Please ask for: Nicola Moore
Email: nicola.moore@arun.gov.uk
Telephone: Ext 37944
Our Ref: FP/76/20/HH
Your Ref:
Date: 22nd May 2020

Application for Planning Permission for Works or Extension to a Dwelling

Development: Single storey garage and storeroom/summerhouse at side of property.
Location: 1 Summerley Lane Felpham PO22 7HN

DRAWING No B1.

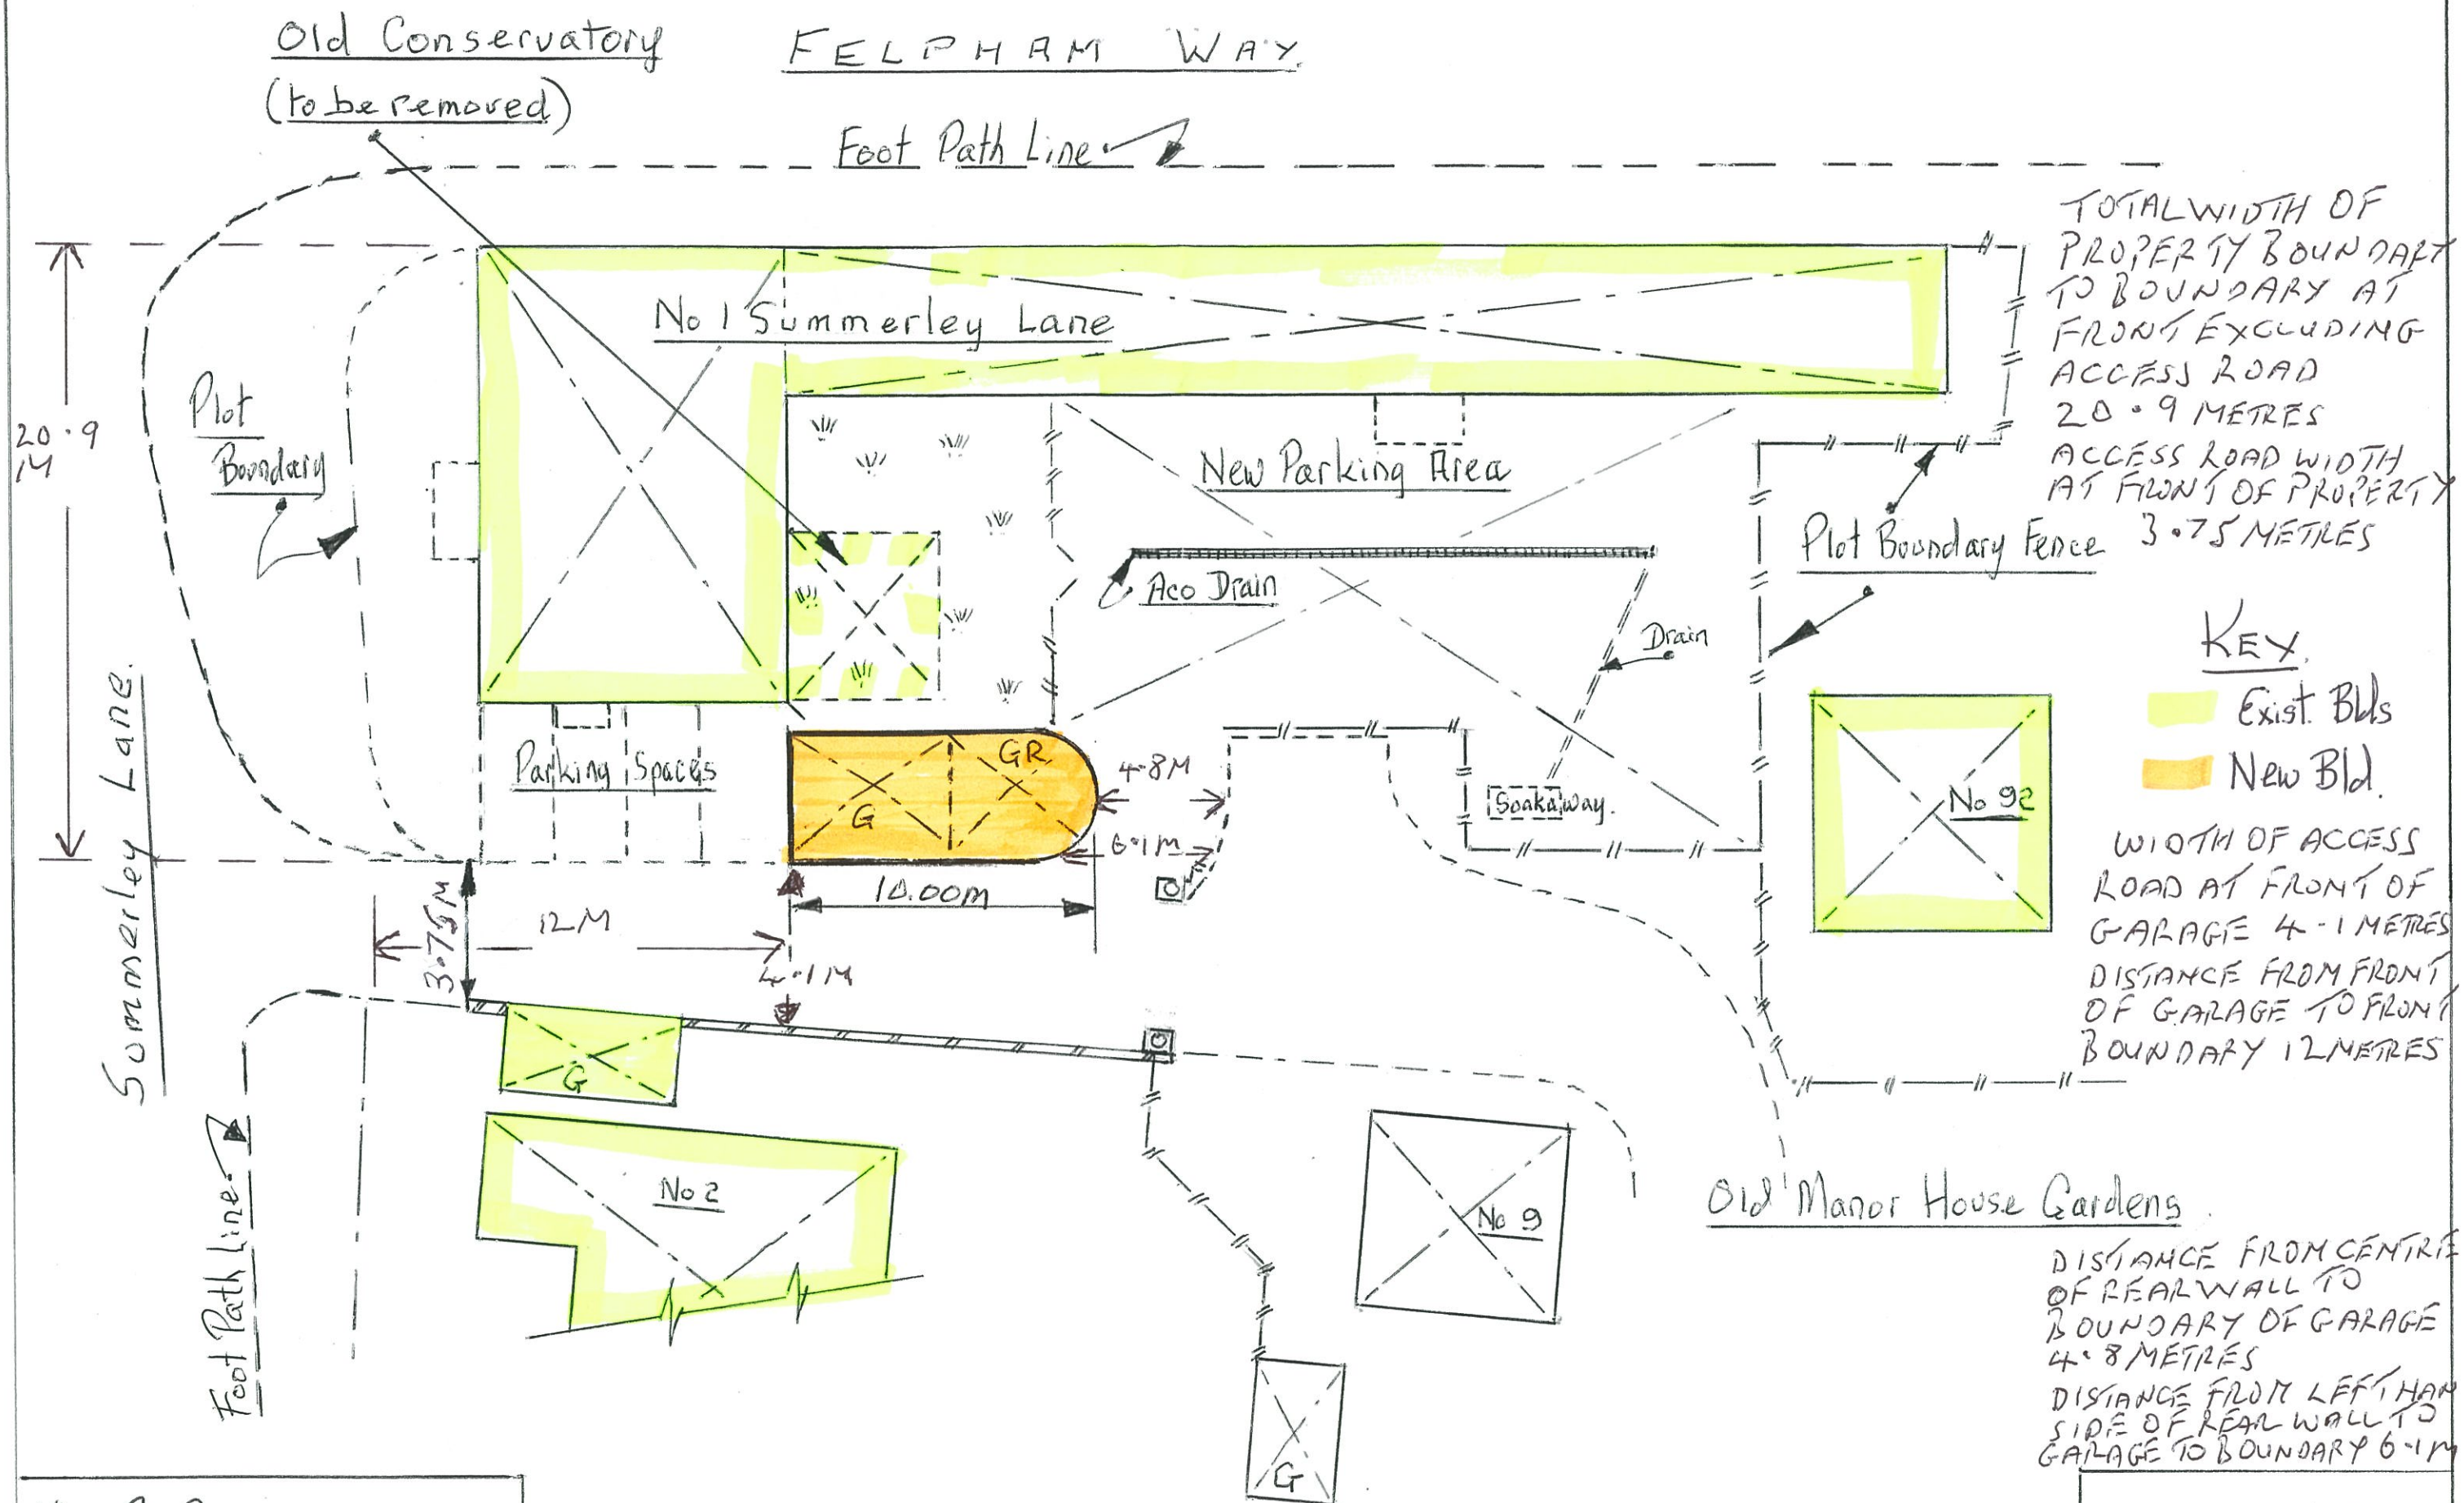
Block Plan

Please include measurements to all boundaries and re submit.
CIL Additional Information Form

FLOOR PLAN

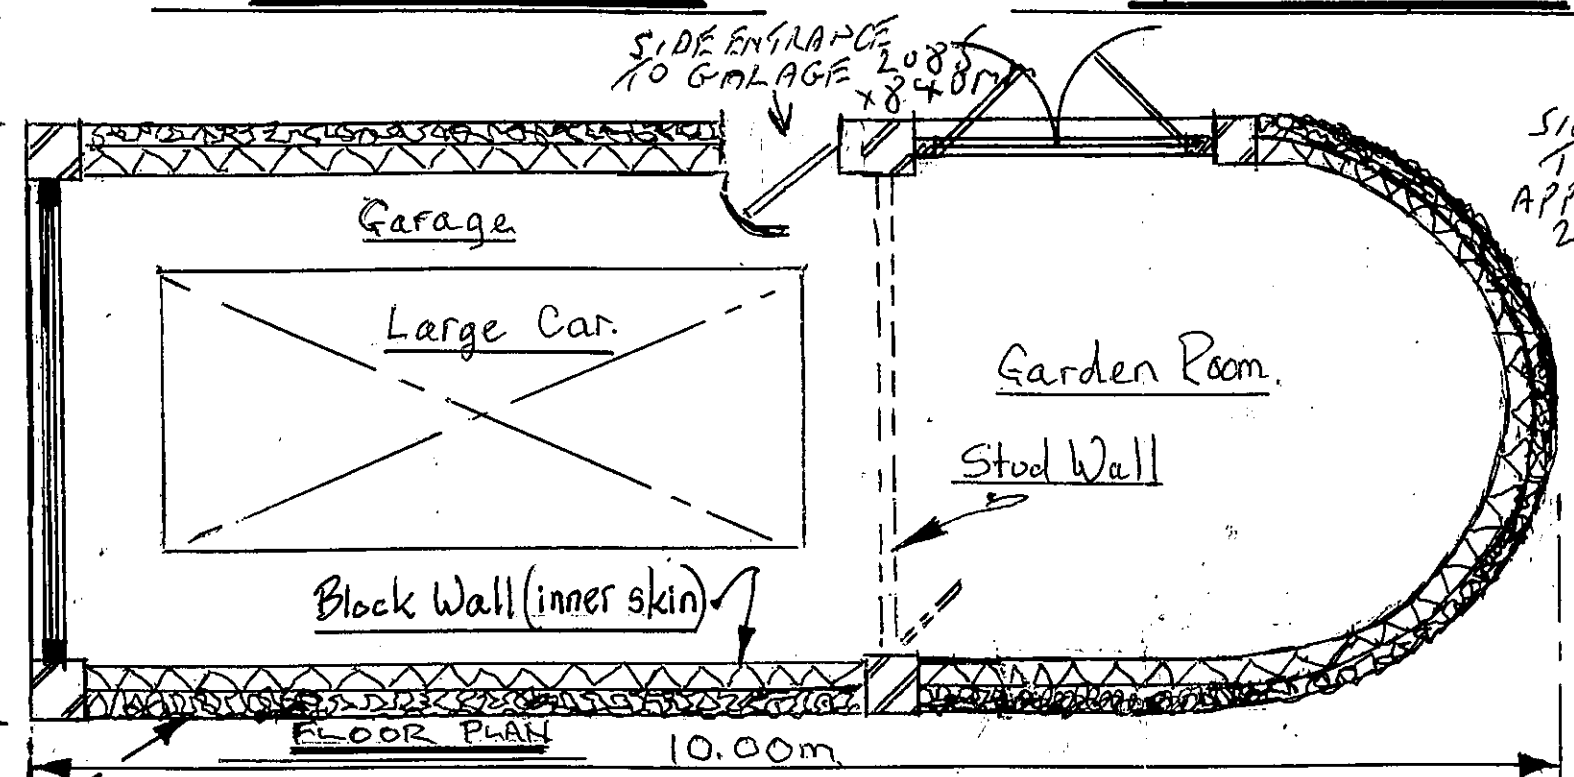
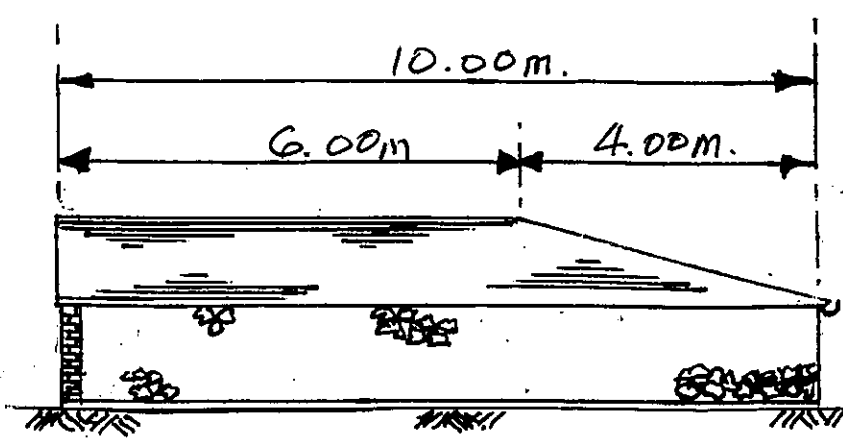
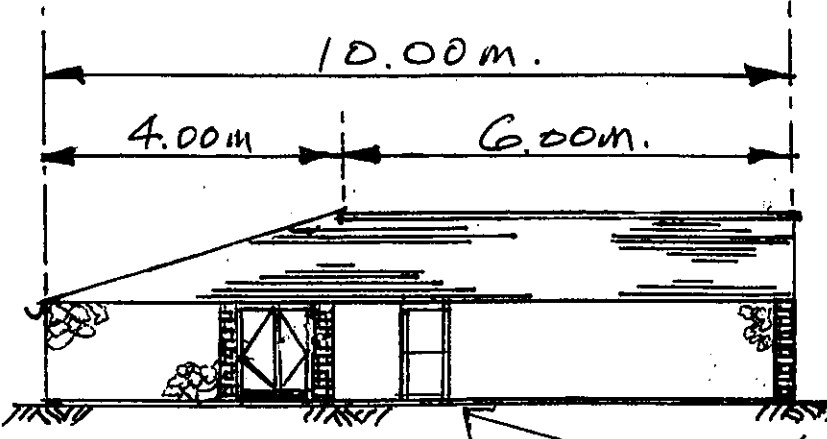
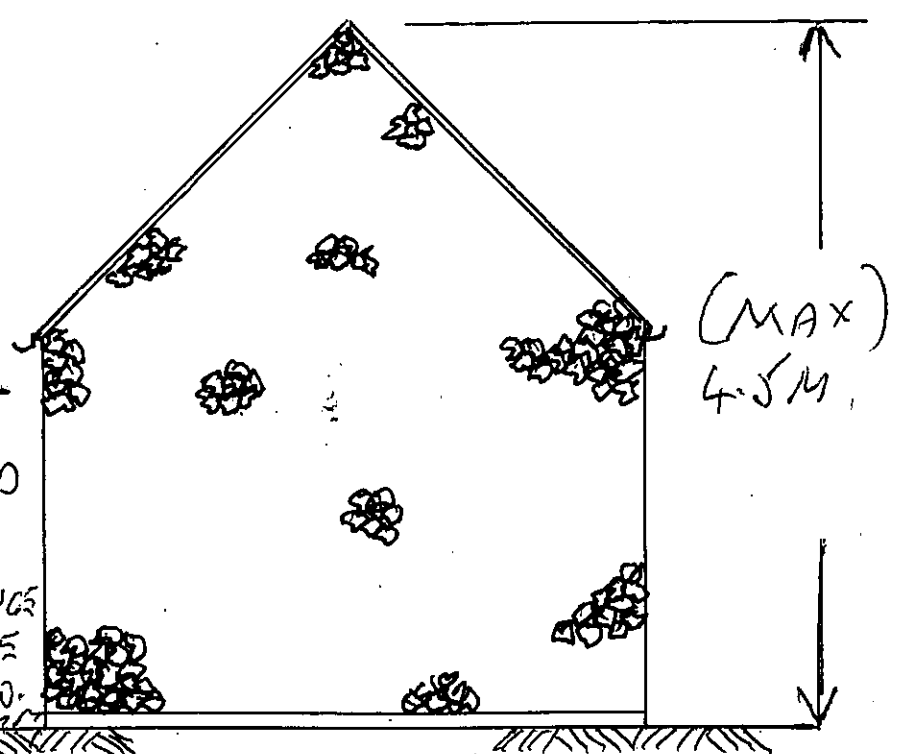
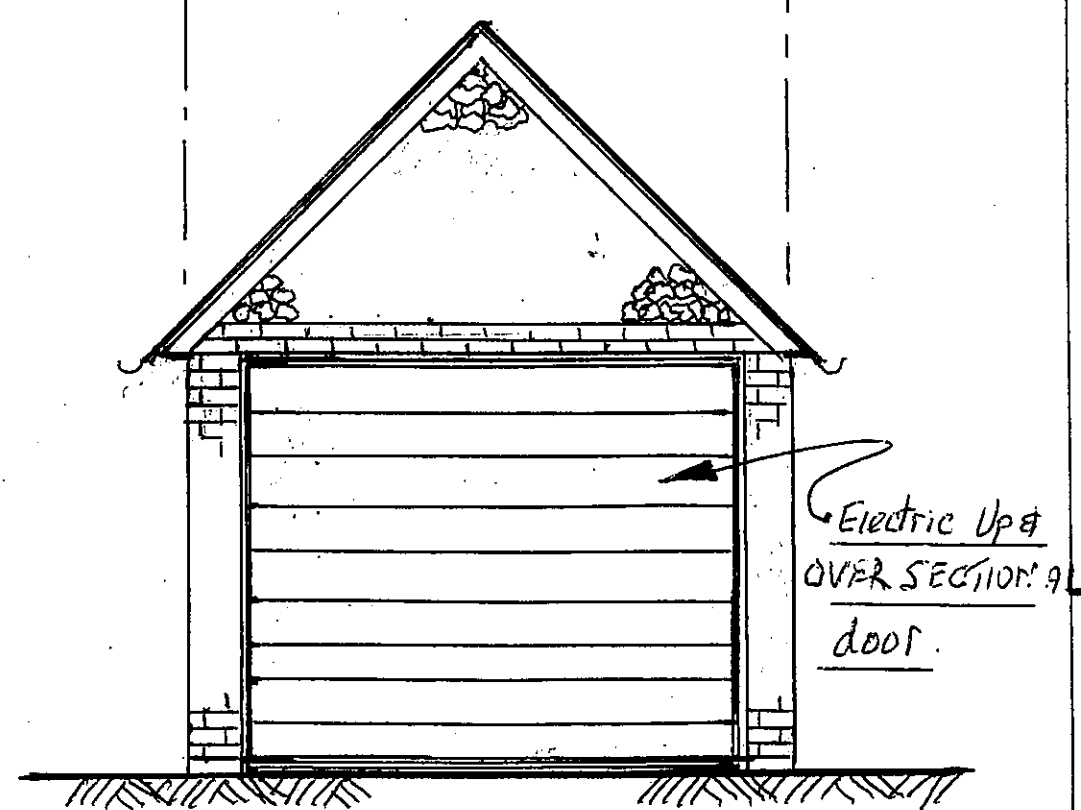
The floor plan and elevations do not accord. Please check the measurements and scales, amend accordingly and re submit.
